Norfolk Boreas Offshore Wind Farm Applicant's Response to Broadland District Council's Local Impact Report

Applicant: Norfolk Boreas Limited
Document Reference: ExA.LIR-BDC.D3.V1
Deadline 3

Date: December 2019
Revision: Version 1
Author: Royal HaskoningDHV

13 APPENDIX 6 SCHEME OF HIGHWAY MITIGATION (B1145, CAWSTON)

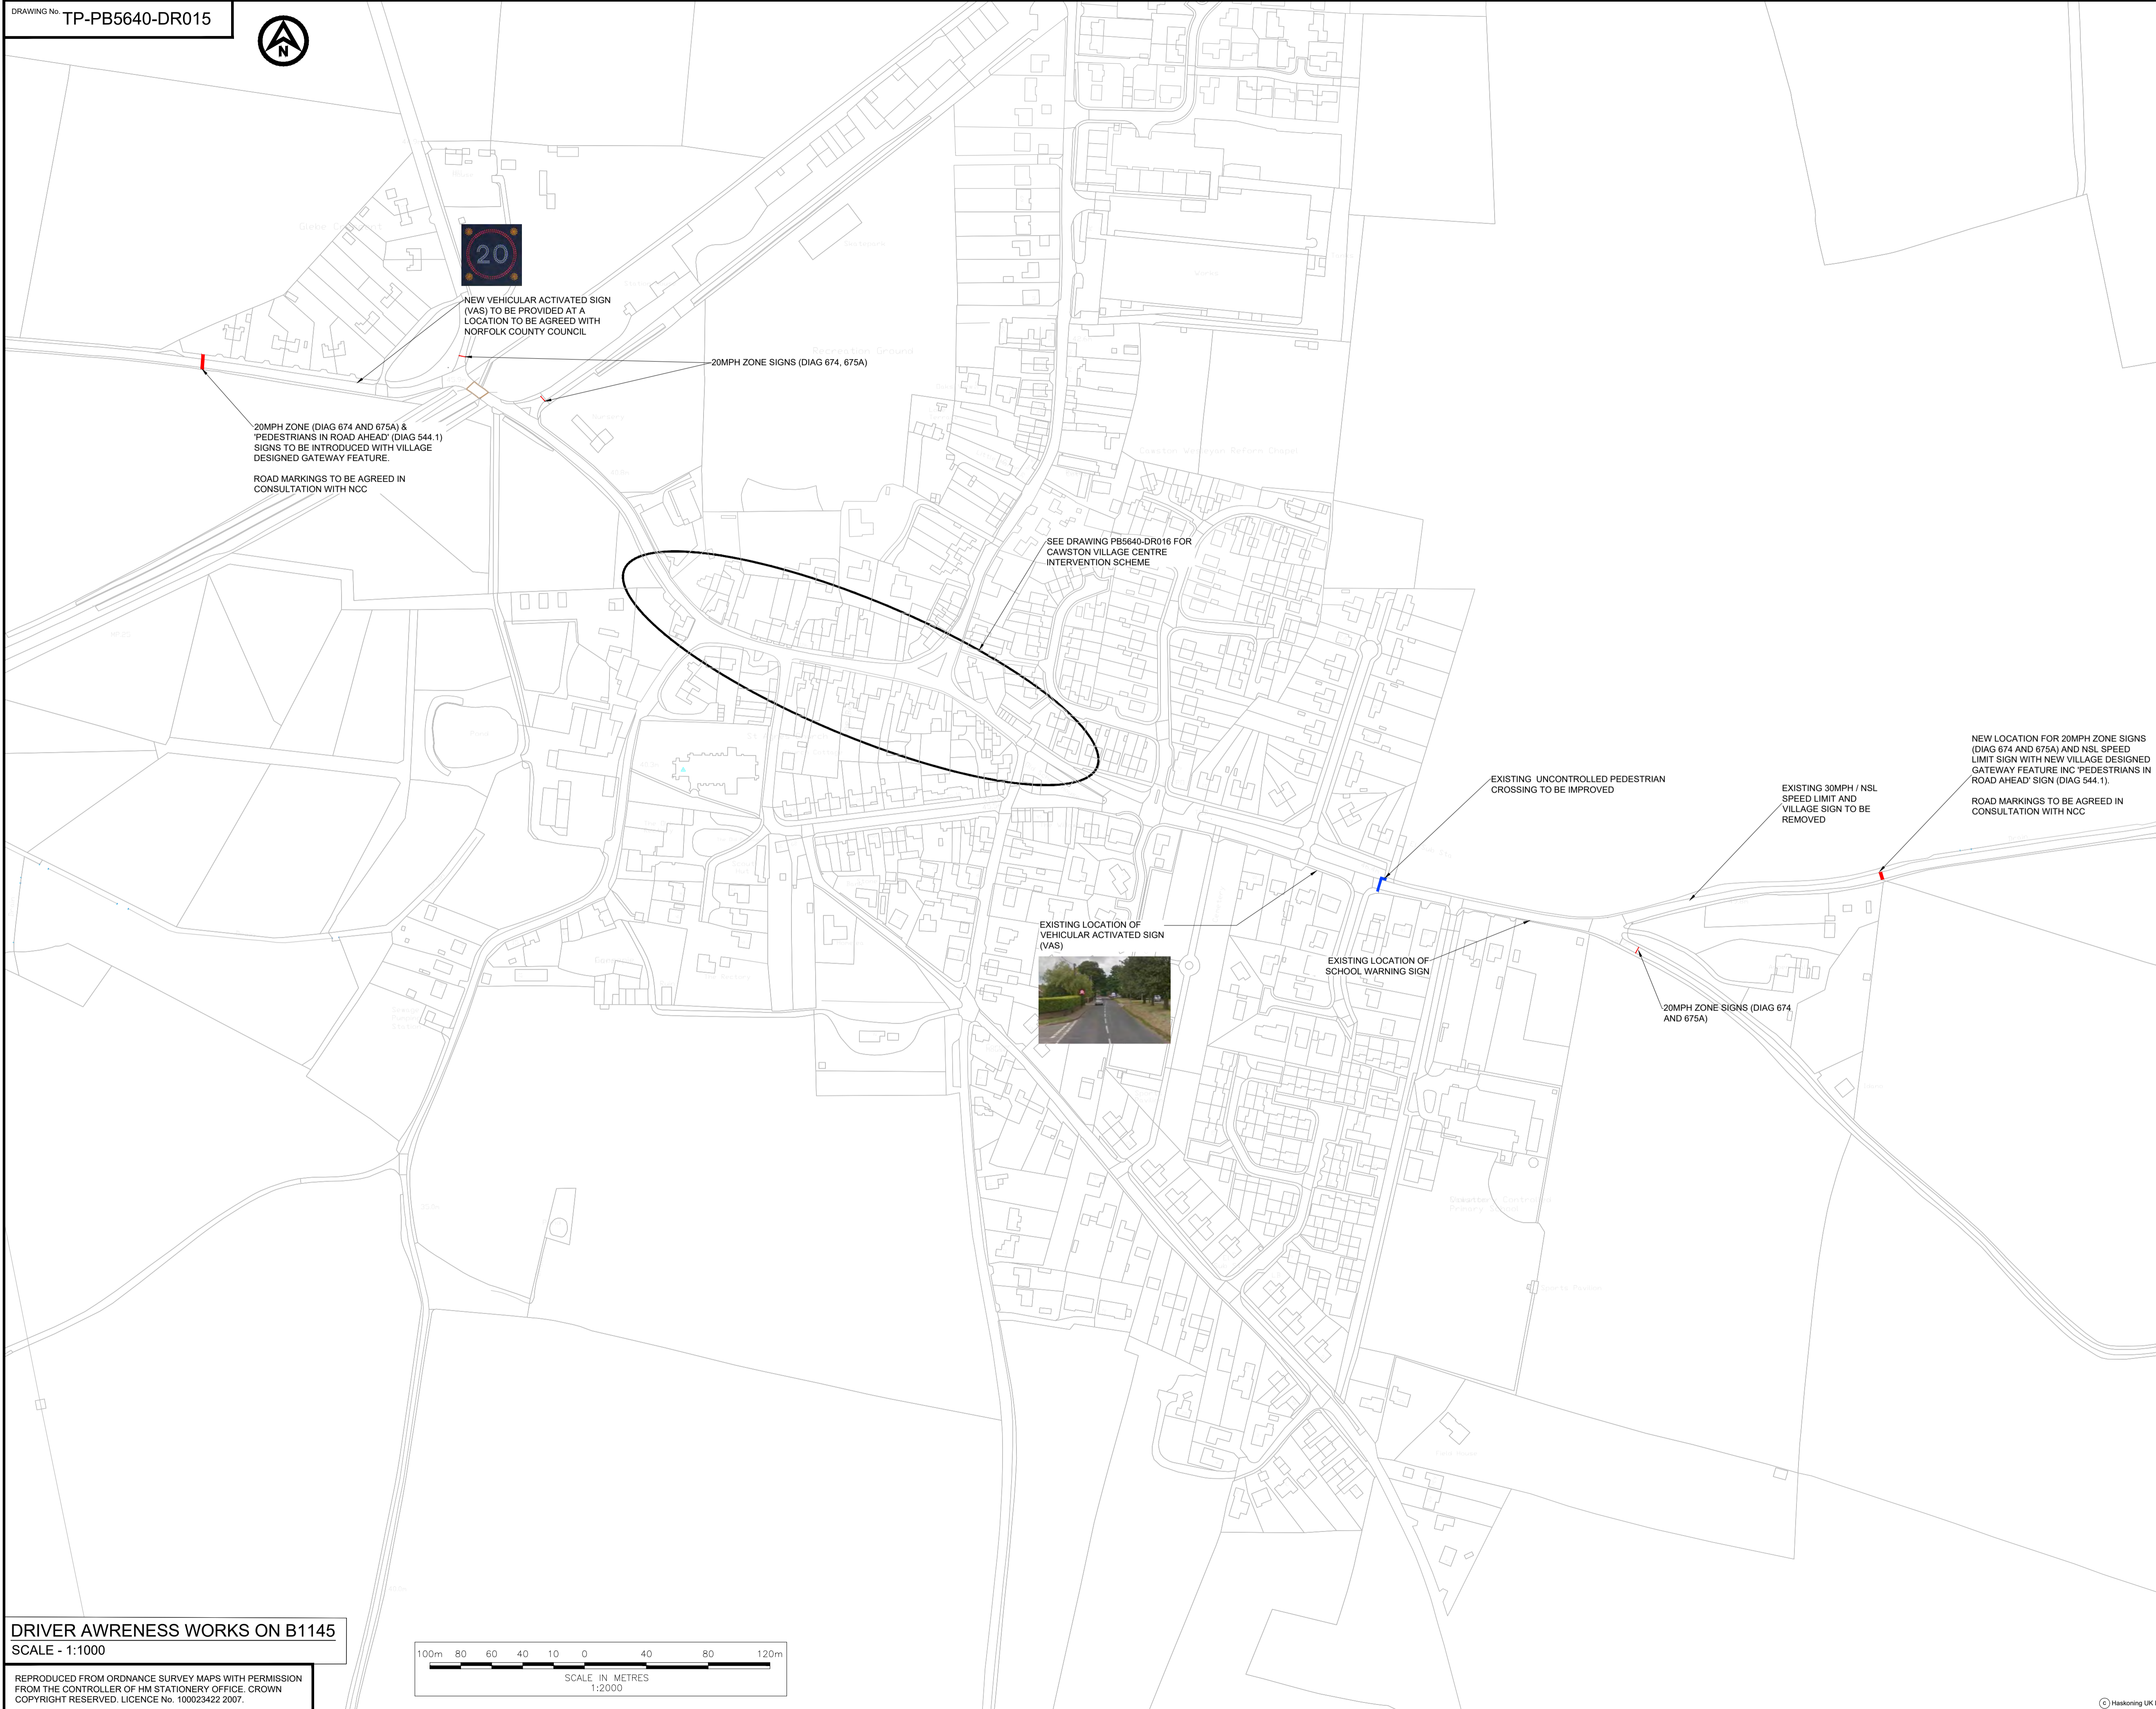
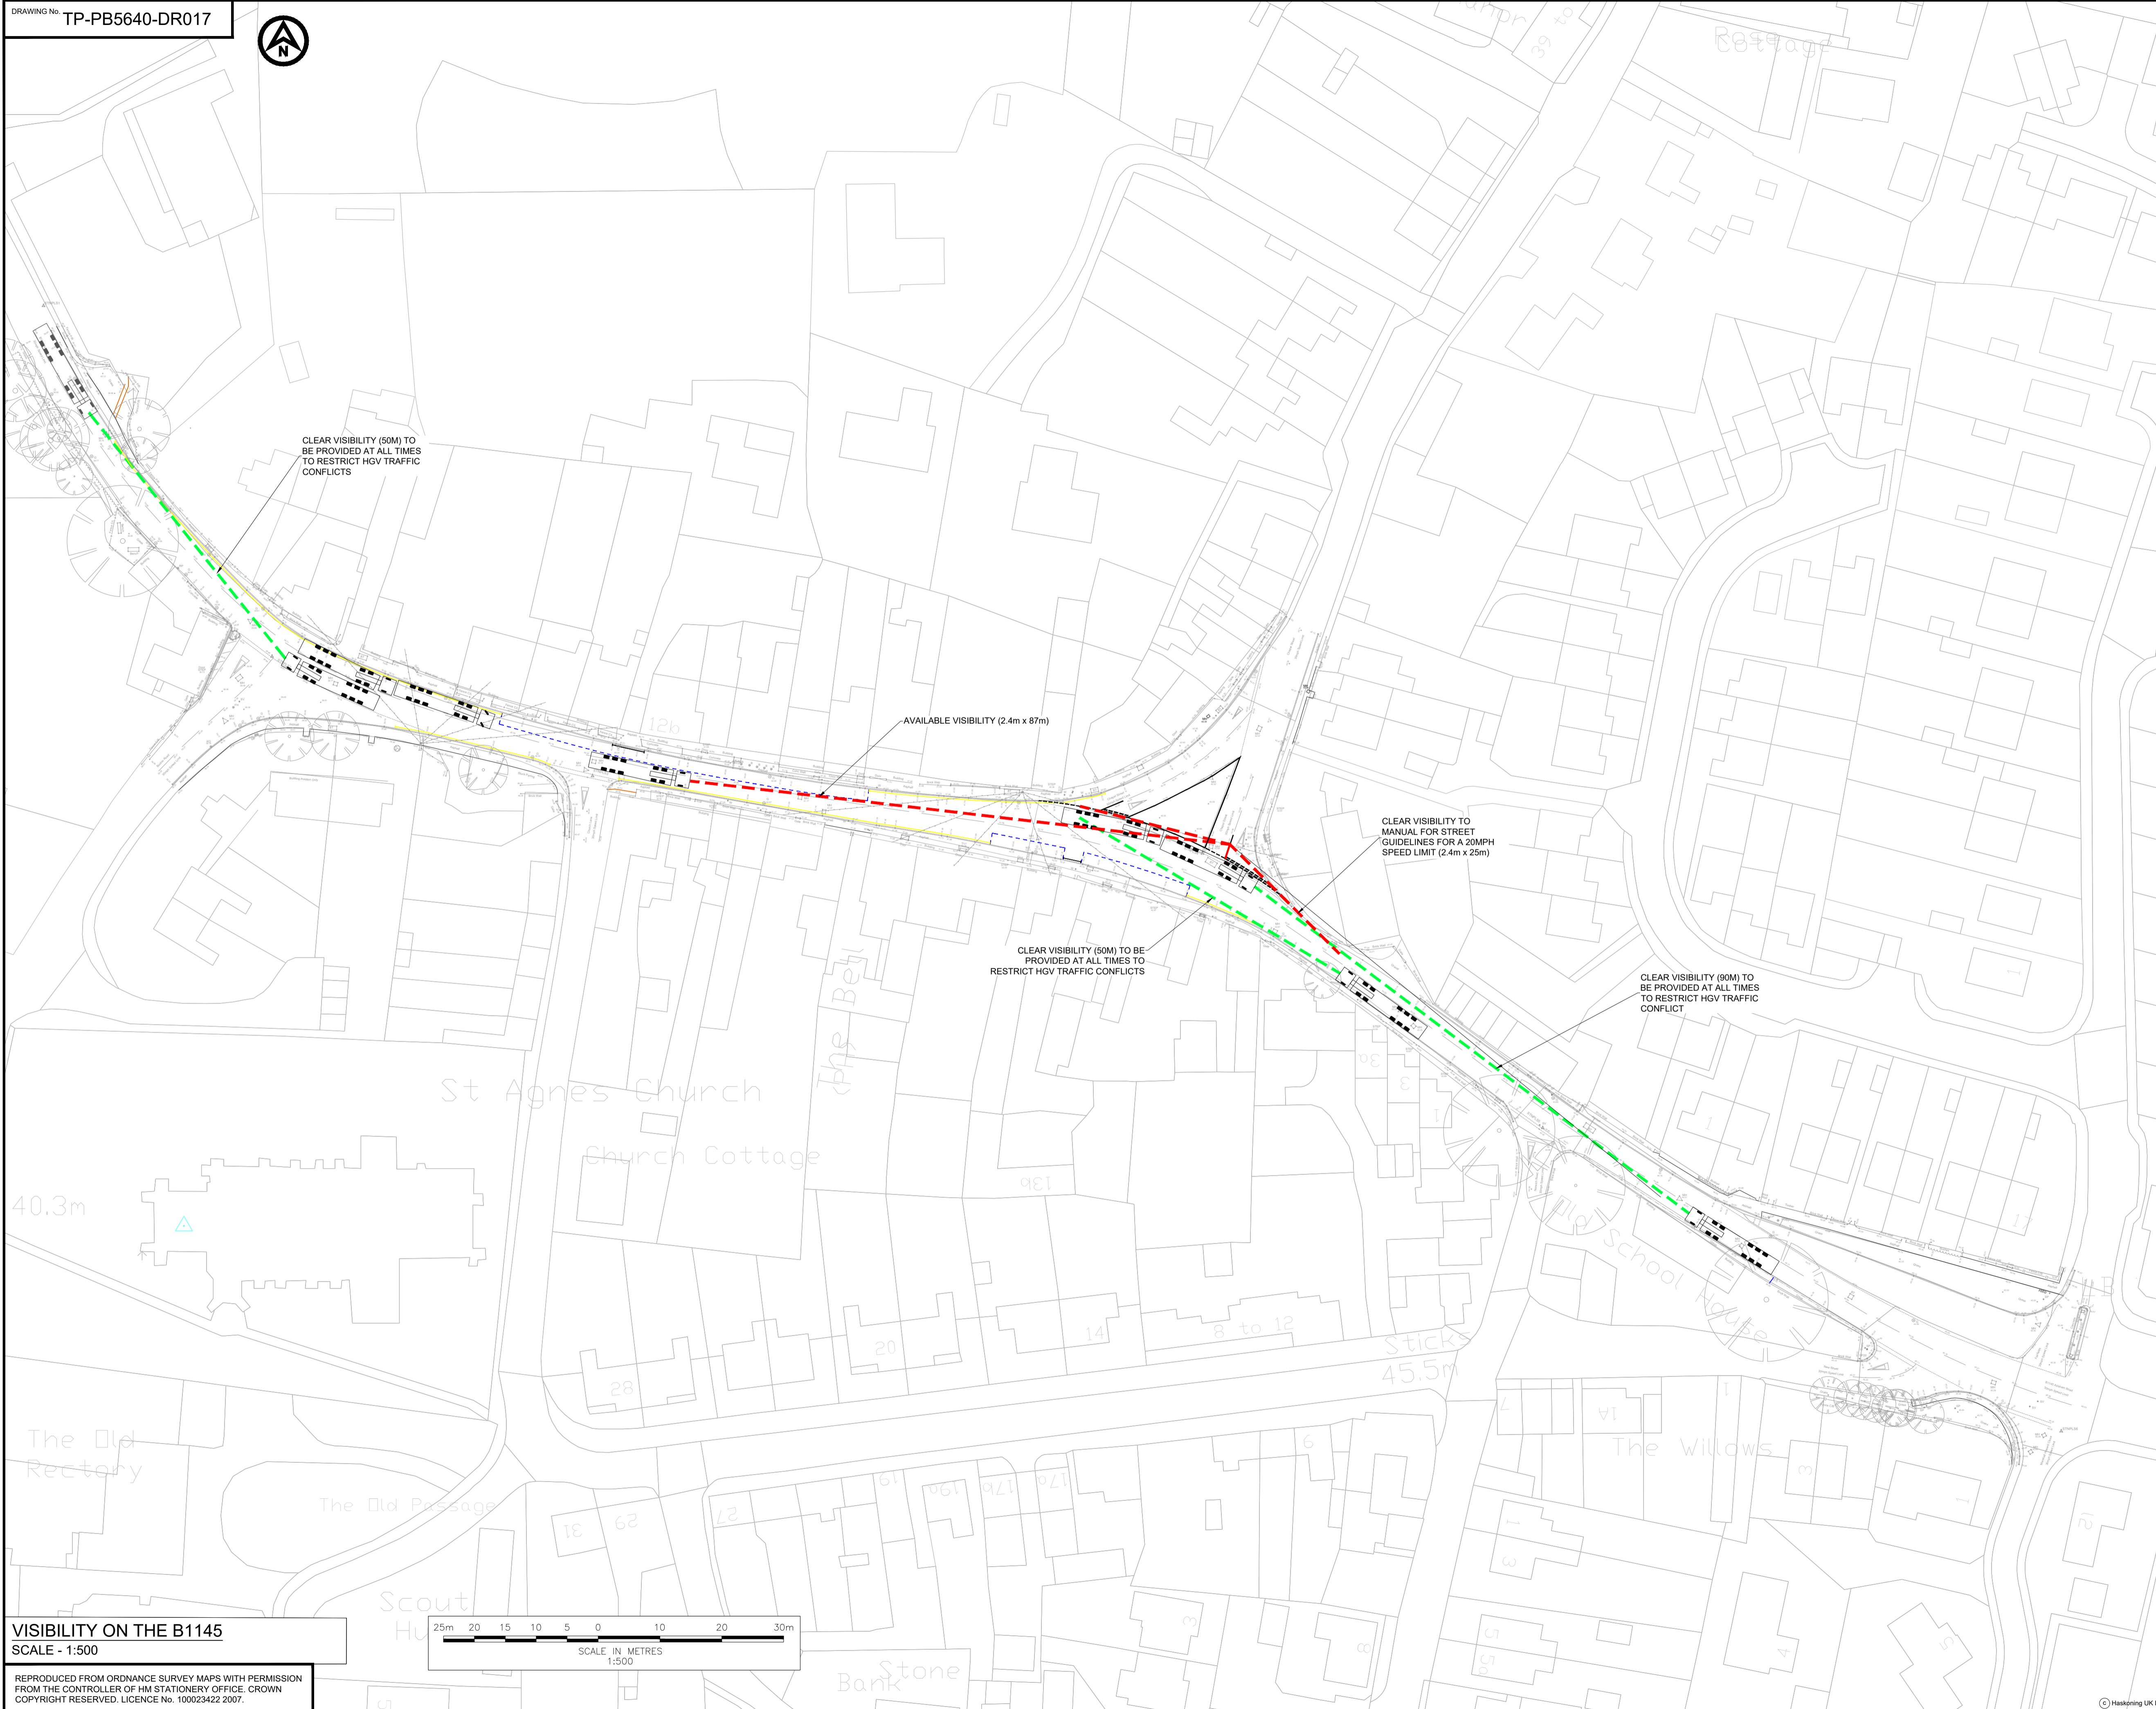
<p><u>c) The cumulative impacts of the construction traffic associated with the proposed Norfolk Vanguard wind farm, the Hornsea Three wind farm and the Norfolk Boreas wind farm on the village of Cawston and the surrounding area.</u></p> <p>5.7 It is apparent that the proposed route of heavy goods construction traffic serving part of the cable corridor will use the B1145 and pass through the centre of the village of Cawston along Aylsham Road and the High Street, which is a two way road that is narrow in places particularly in the village centre with no parking restrictions along its length and a significant number of vehicles park on the highway, especially along the High Street. The western part of Cawston is a Conservation Area and a number of properties along the High Street are listed residential and commercial properties which are located in close proximity to the road, some are Grade II* listed.</p>	<p>An assessment of cumulative noise, vibration and air quality impacts associated with Norfolk Boreas and Hornsea Project Three along the B1145 through Cawston has been assessed (section 25.9 of ES Chapter 25 (APP-238) and section 26.8 of ES Chapter 26 (APP-239)).</p> <p>Mitigation is proposed, consistent with those agreed by Norfolk Vanguard and Hornsea Project Three, in the form of a cap on the maximum number of daily HGV movements, temporary speed restrictions, resurfacing the road, incorporation of formalised parking and parking restriction, localised pavement widening and priority warning signs. With these mitigation measures in place residual impacts related to noise, vibration and air quality are not significant based on the agreed Environmental Impact Assessment criteria. These measures are captured within</p>

Broadland District Council Local Impact Report	Applicant's Response
<p>5.8 The information provided to date indicates that heavy goods construction traffic driving in both directions into and through Cawston from the east and also return trips into and through Cawston from the west, will significantly increase as a result of the Norfolk Vanguard project, together with vehicles associated with the separate Orsted Hornsea Three project. The actual range of the increase, the type of vehicular movements that will be generated by the Norfolk Boreas project and the route of construction traffic on the highway network around Cawston must be considered and fully assessed.</p> <p>5.9 Both the Hornsea Three and Norfolk Vanguard projects propose a traffic mitigation scheme within the village centre of Cawston along the High Street to include dedicated on-street parking areas, footway widening/c carriageway narrowing with the formation of waiting areas either side of the centre so that only single way HGV's can manoeuvre through a section of the village centre at a time with a reduced speed limit and the carriageway re-surfaced. The mitigation scheme is still to be finalised in the respective Construction Traffic Management Plans, should approval for each project be forthcoming. As a result of the Norfolk Vanguard proposals the total number of HGV's passing through the centre of Cawston were reduced and Norfolk Boreas should commit to match these or even reduce the level of HGV's required in scenario 2 with further detailed analysis of the additional cumulative traffic impacts as a result of development in scenario 1.</p> <p>5.10 BDC welcomes continued involvement and consultation with the applicant, the Highway Authority and Cawston Parish Council as the number, type and periods of construction traffic activity are clarified and whether alternative routes for the construction traffic can be utilised. Consideration needs to be given to any impacts on heritage assets, highway safety and the residential amenities of occupiers in Cawston including issues of noise, disturbance and vibration arising from the increased heavy goods construction traffic in the village. Until an acceptable alternative has been secured BDC has serious concerns about the impact of the cumulative significant increase in heavy goods construction traffic in Cawston as a result of up to three nationally significant infrastructure projects.</p>	<p>section 4.3.3 of the Outline Traffic Management Plan (OTMP) (PRE1-022) and secured through DCO Requirement 21.</p> <p>Following discussions with Cawston Parish Council and Broadland District Council as part of Norfolk Vanguard, the Applicant has sought to further optimise the construction programme to reduce the Norfolk Boreas peak traffic as low as practicable. As such, the Applicant is able to commit to a Norfolk Boreas Scenario 1 peak of 112 (reduced from 133) daily HGV movements (in both the single project and cumulative scenario) and for Norfolk Boreas Scenario 1 peak of 61 daily HGV movements (in both the single project and cumulative scenario).</p> <p>The mitigation scheme is still to be finalised and the Applicant is currently refining the scheme design and will continue to engage with Norfolk County Council, Broadland District Council and Cawston Parish Council as the scheme design progresses (for further details see the Applicant's Comments on Responses to the ExA First Written Questions (document ExA.WQ-1.D3.V1, section 14.0 Traffic and Transport).</p> <p>Any material changes to the scheme will be reviewed in the context of the Air Quality and Noise and Vibration assessments presented in the Norfolk Boreas Environmental Statement and the Heritage Assessment (included as Appendix 2 of the Statement of Common Ground with Broadland District Council, document reference ExA.SoCG-3.D2.V1, REP2-047).</p>
